Subject: Rezoning Petition Review

From: Doug Lozner

Rezoning Petition #: 22-109

Location of Property: Approximately 2.09 acres located on the northeast side of The Plaza, south of Bridgeport Dr and west of Barrington Dr.

RZ-1

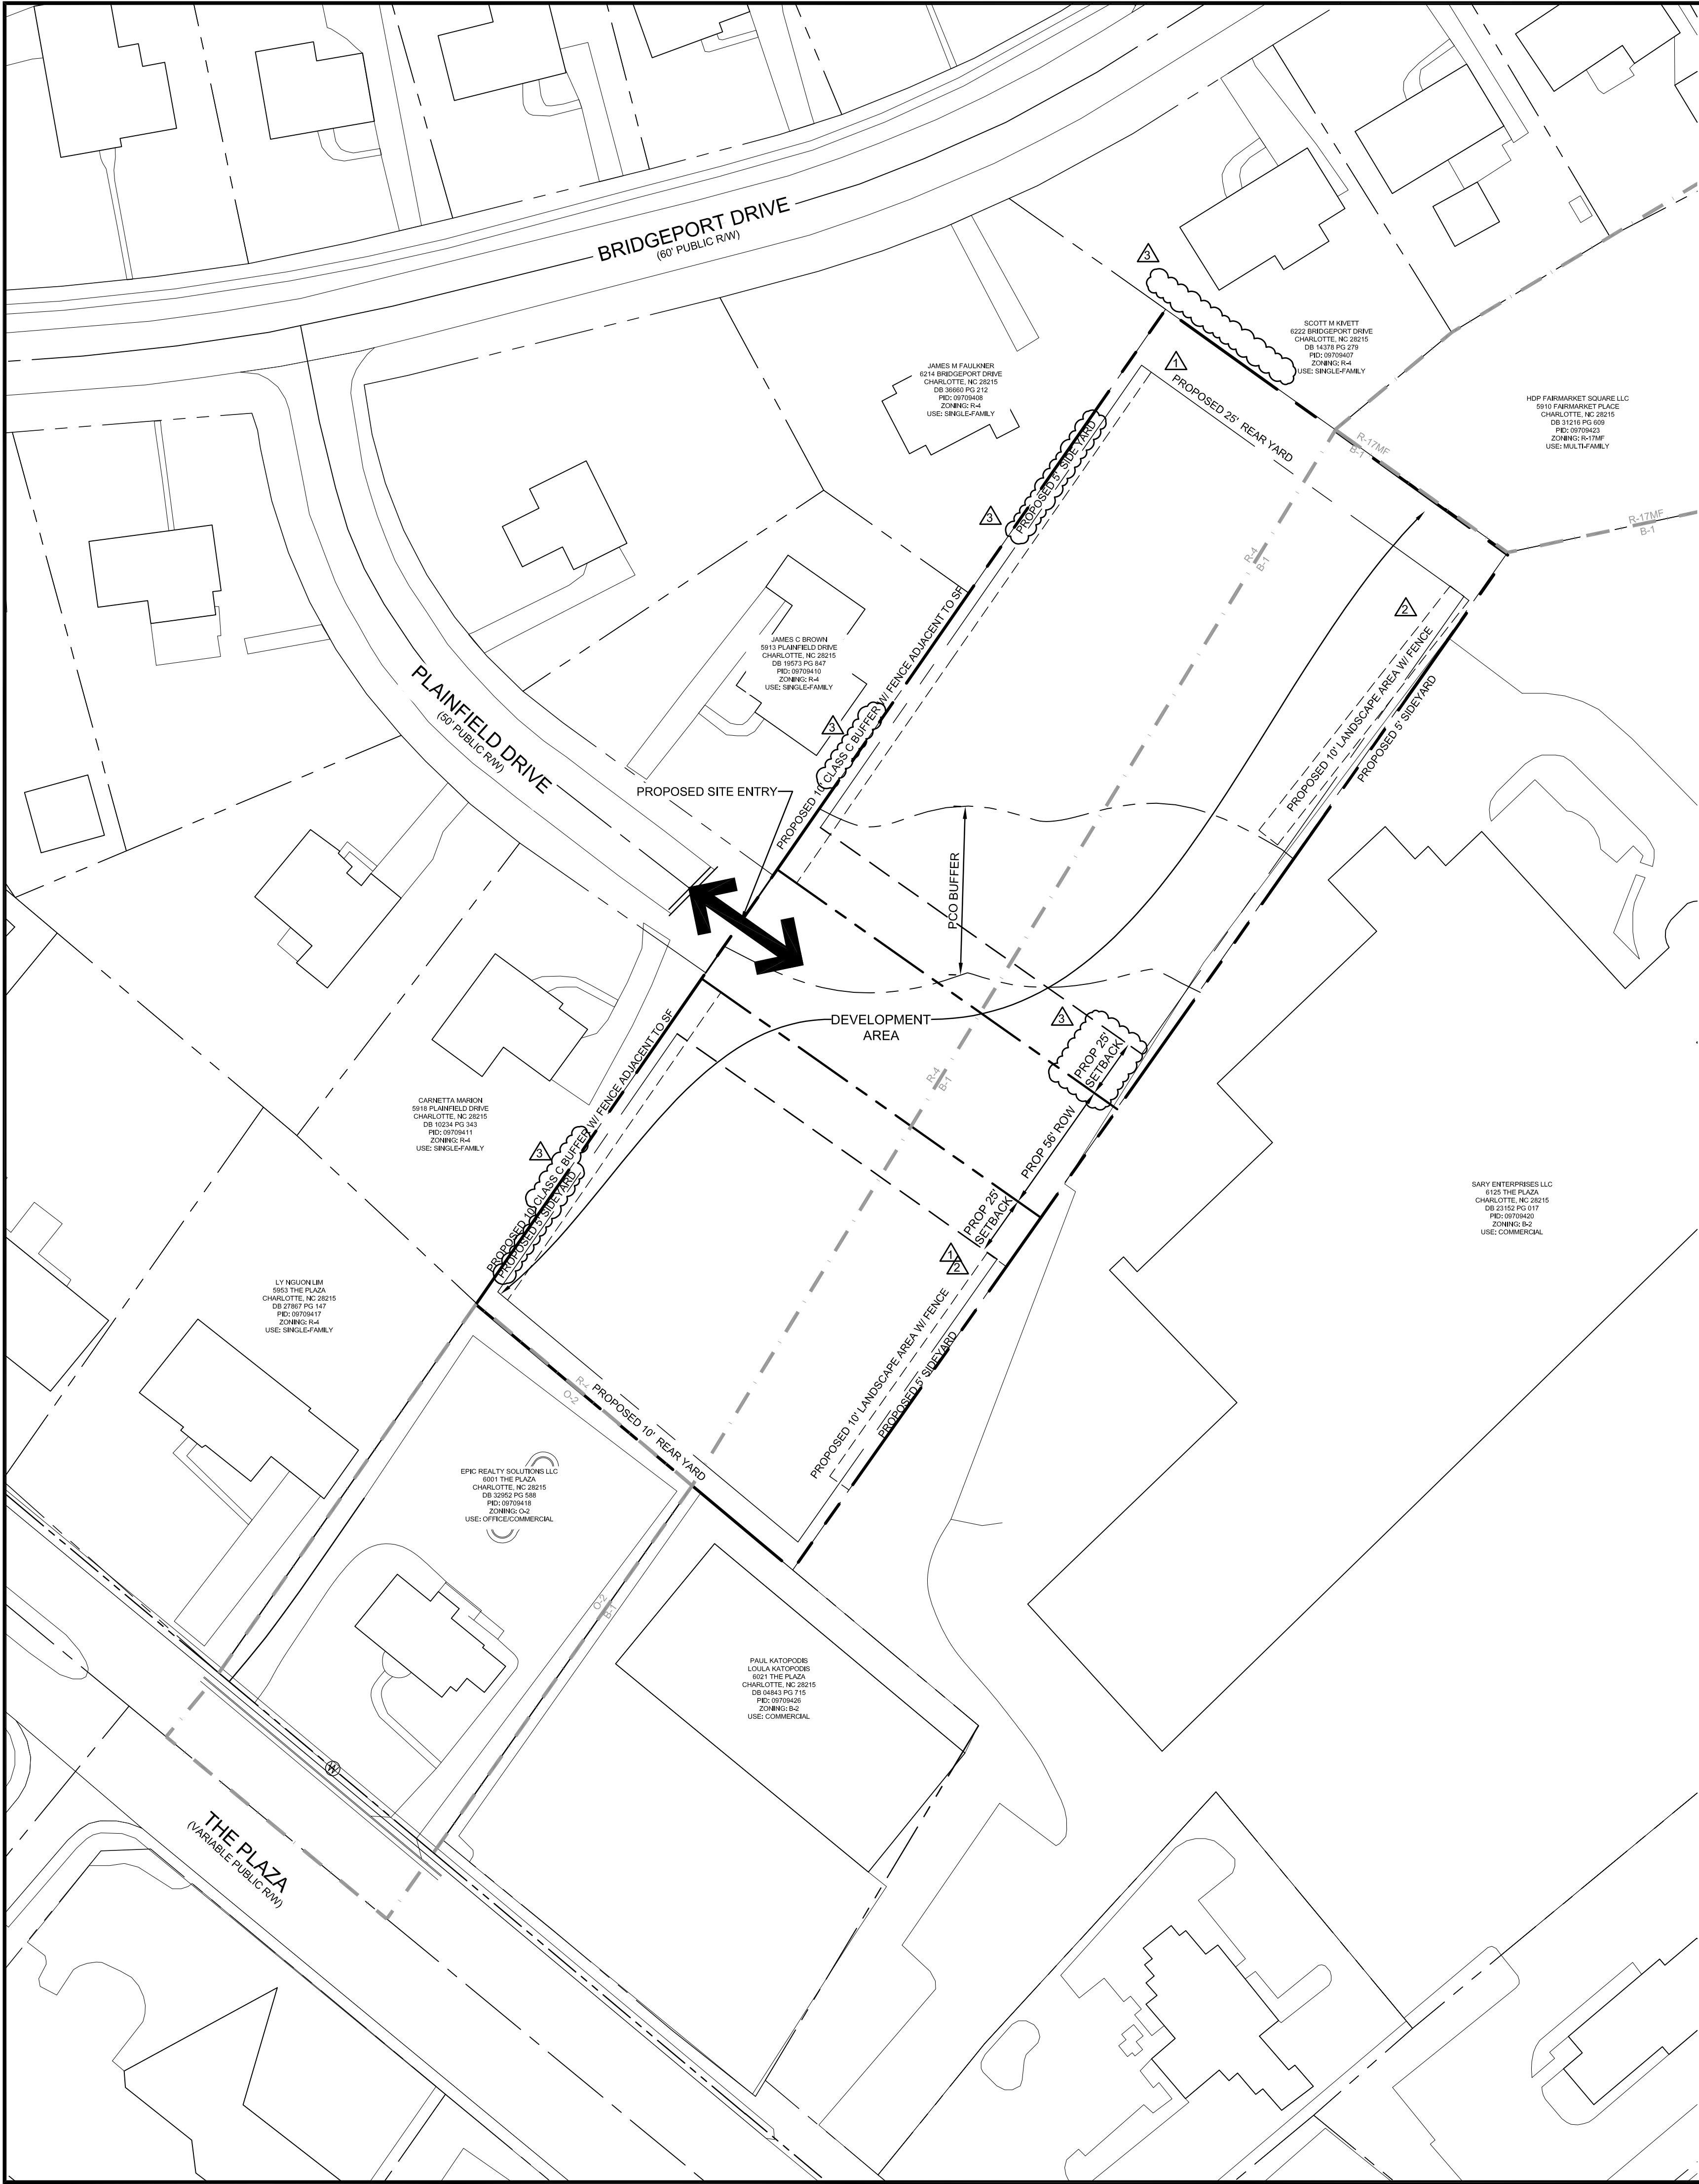
City of Charlotte GIS data indicates a 30-ft PCSO Buffer crossing the site. Any increase of impervious area within SWIM/PCSO buffers may not be allowed and is not approved with the rezoning process. Please include the following note under Environmental Features: *“Development within any SWIM/PCSO Buffer shall be coordinated with and subject to approval by Charlotte-Mecklenburg Storm Water Services and mitigated if required by City ordinance. Petitioner acknowledges intermittent/perennial stream delineation reports are subject to review and approval upon submission of development plans for permitting and are not approved with rezoning decisions.”*
